We attach a detailed list of objections to the above planning application which is a revised application of FG/186/18/PL and FG/220/18/PL. The latter application was refused by Arun District Council on the grounds that the new dwelling would have an unacceptable impact on the residential amenity of neighbouring properties, including the host dwelling in terms of loss of light, overbearing impacts and loss of privacy, contrary to policy D DM1 (3) of the Arun Local Plan. The appellant's appeal was dismissed by HM Inspectorate on the grounds of 'the harmful overbearing impact on the occupiers of the host property and harmful loss of privacy to the occupiers of Magalia, contrary to policy D DM1 of the Arun Local Plan.

It seems to us that the new proposal in application FG/141/19/PL makes only minor changes to the proposed property. Our objections remain as follows -

PROPOSED SOUTH (FRONT) ELEVATION 1:50.

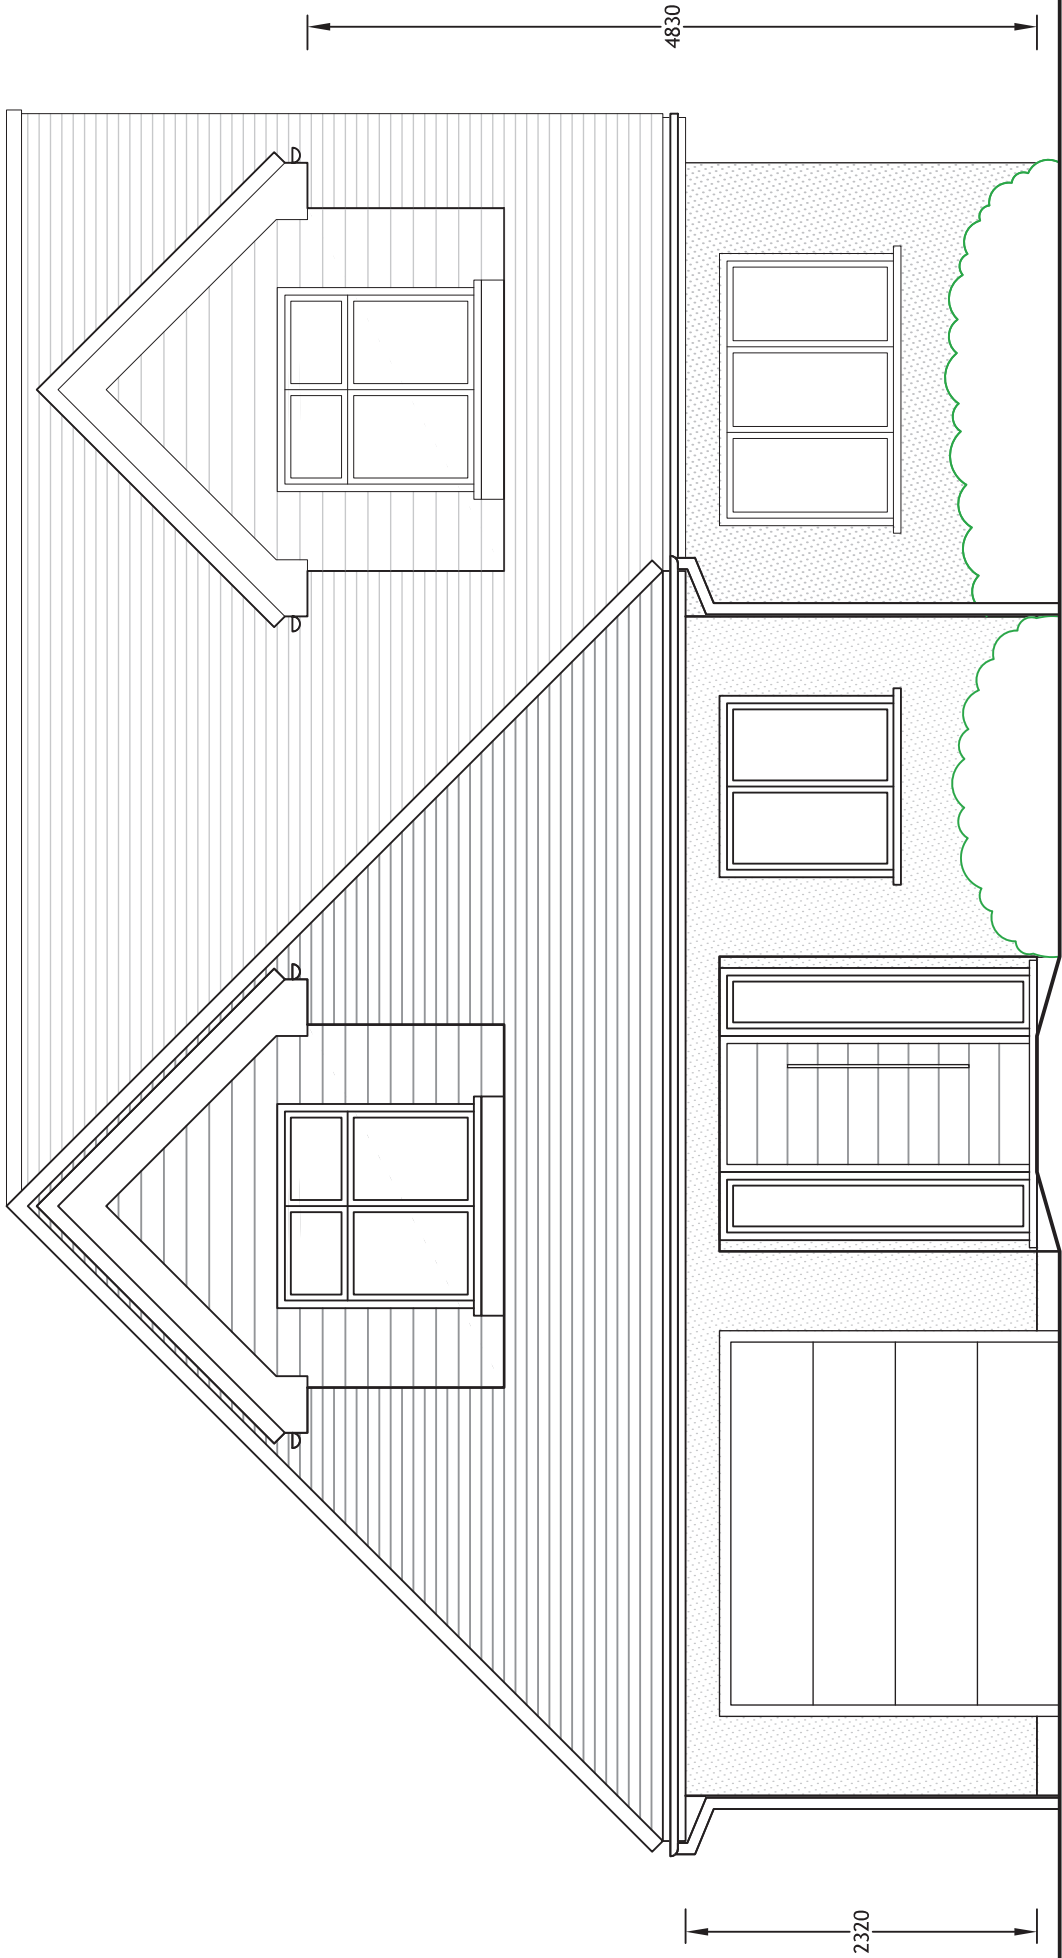
1. Alterations to South facing windows using obscure glass with non-operable windows does not guarantee long term privacy. We strongly suspect that it would only be a matter of time before current or future owners revise the room layout and replace windows with clear openable glass windows.

3. We would contend that notwithstanding the proposed window alterations, the sheer size of the proposed property would dominate the street scene of Tamarisk Way and its surrounds. The Inspectorate drew clear attention to the proposed property's impact on Magalia in particular and was a major reason for the appeal's dismissal.

PROPOSED SITE PLAN

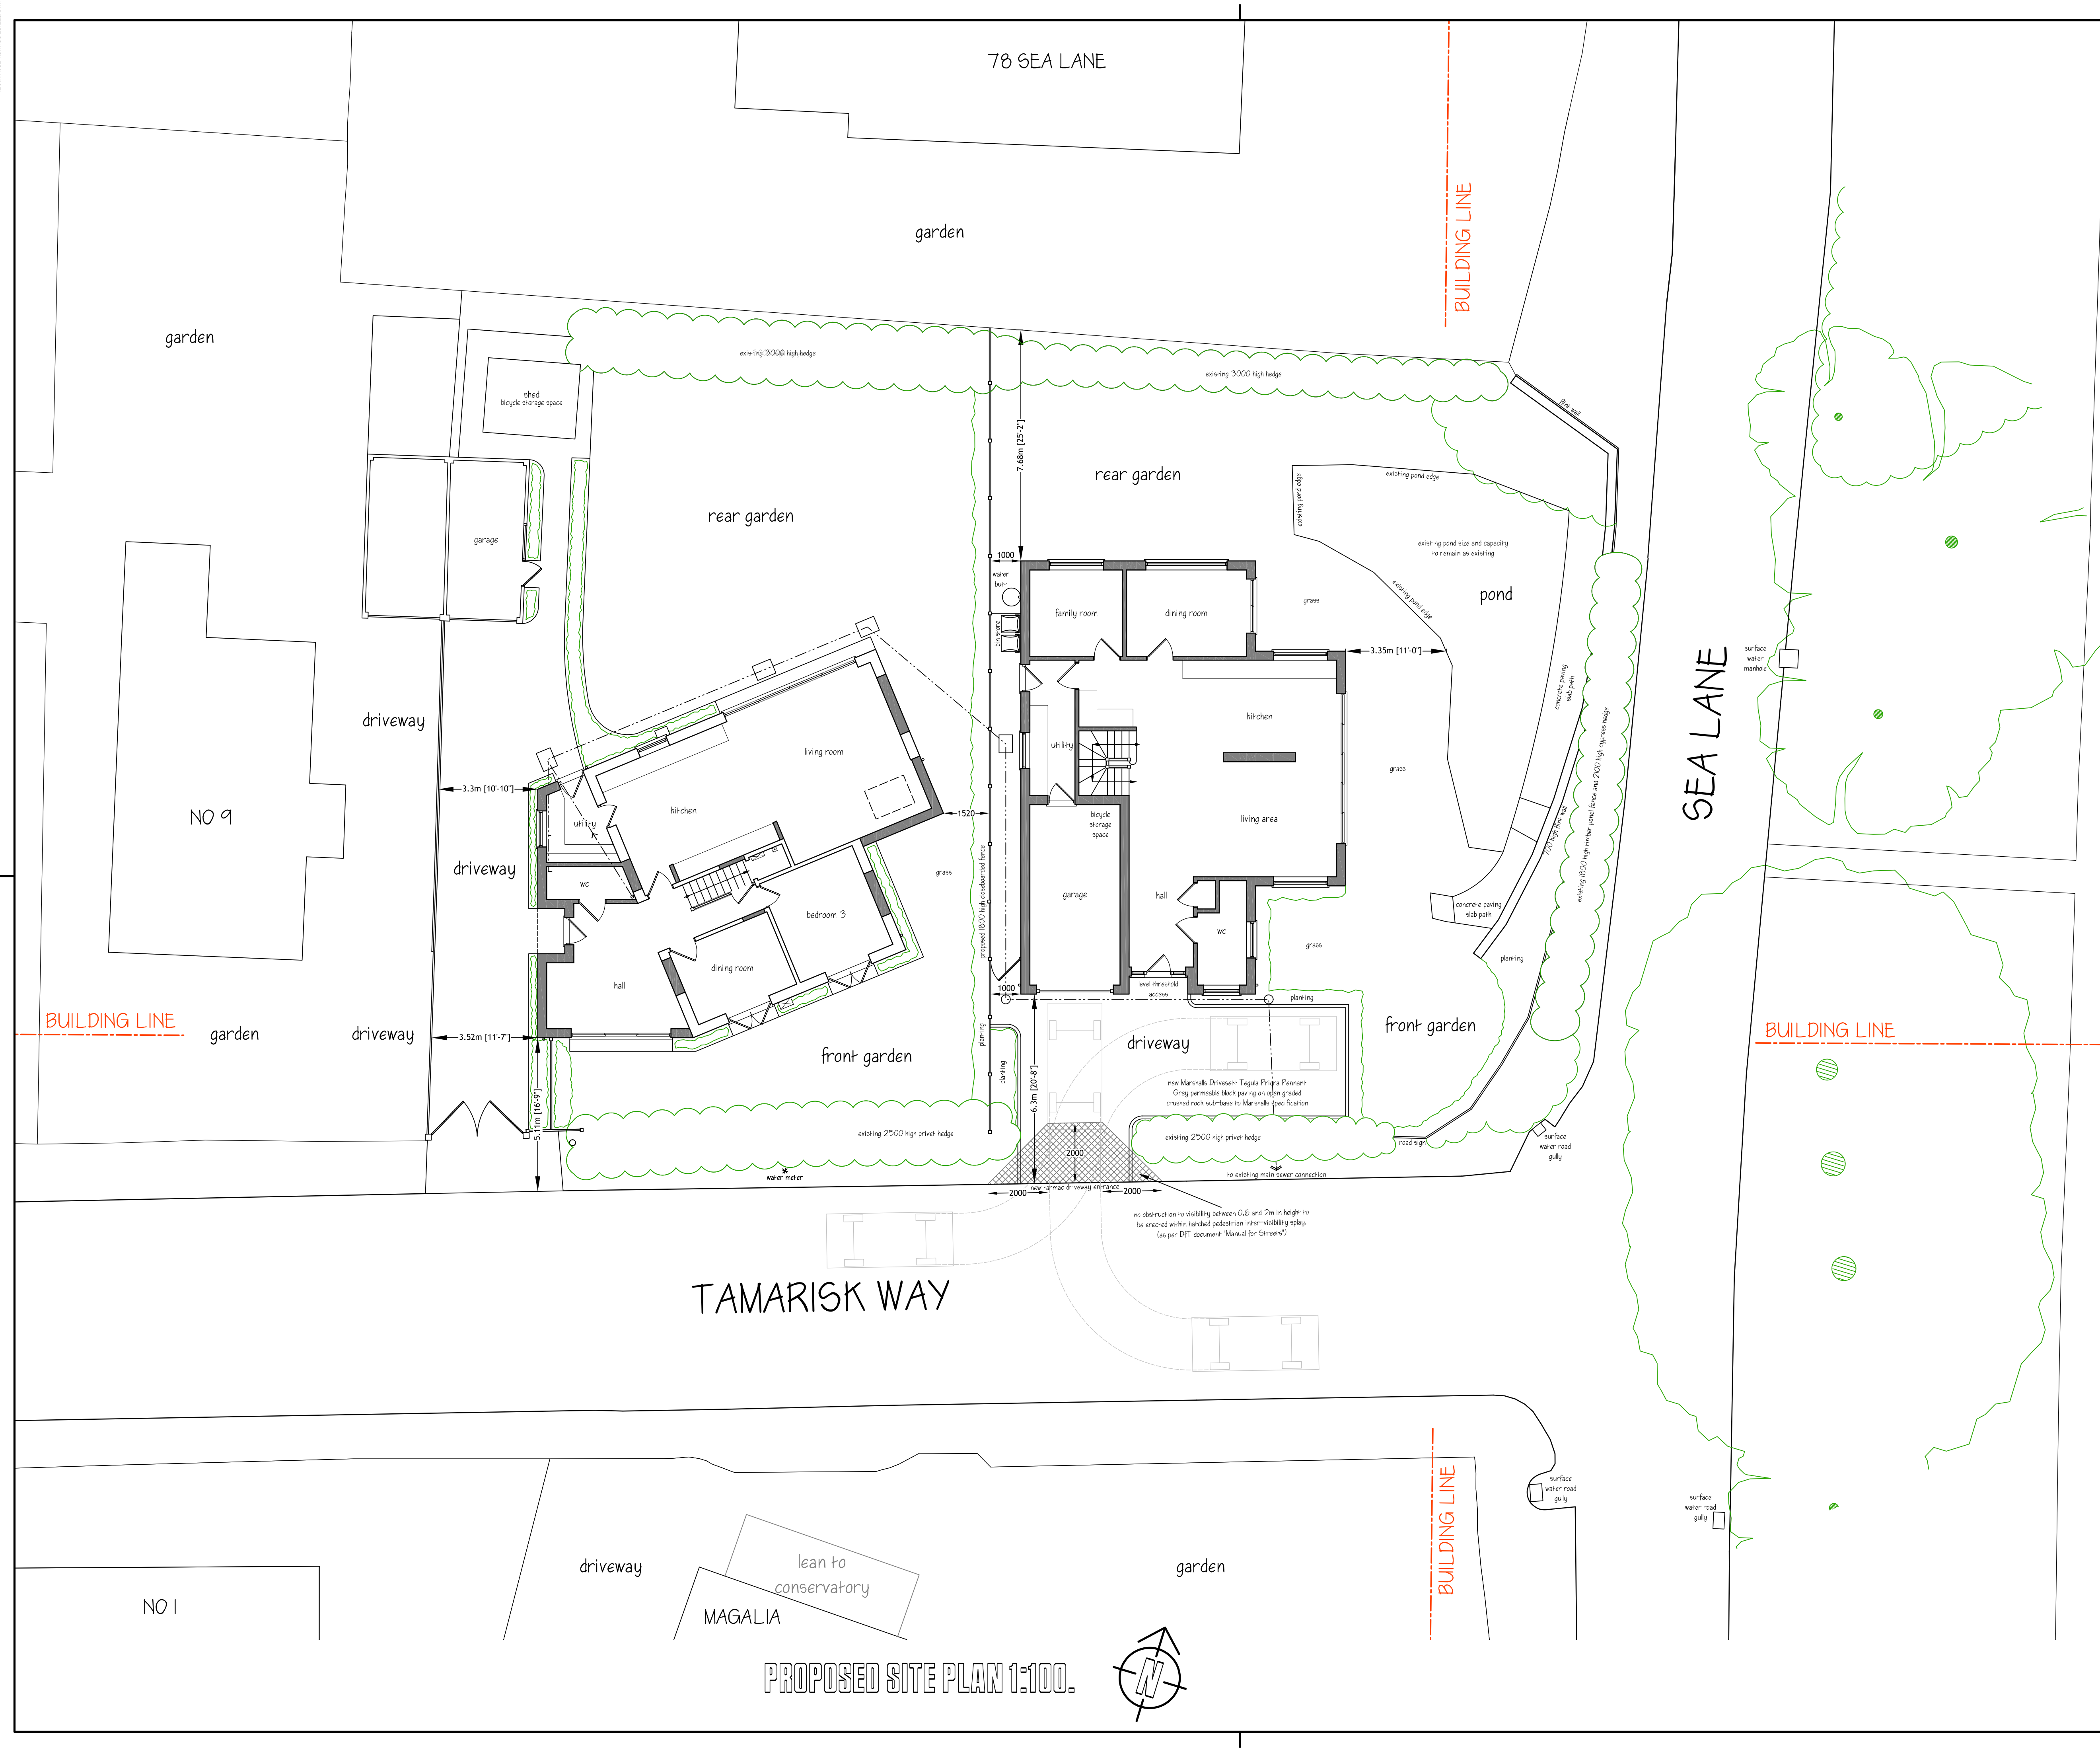
2. Since no further relocation of the proposed property appears possible, its proximity to the drainage channel, pond and west side boundary fence (only 1.5m from the host property) remain unresolved. Many previous objectors have identified this as being unacceptable, citing a cramped, overdeveloped and unneighbourly use of space, contrary to D DM1.

4. This is a new application and consequently we would draw attention to the threat of flooding from the surface water drainage pond, as we and others have previously indicated. Although the pond can become dry in periods of drought, it is (as it is currently) full during periods of rainfall and can overflow in times of heavy rain. We understand that ADC engineers required pond levels to be monitored through 2019/2020.
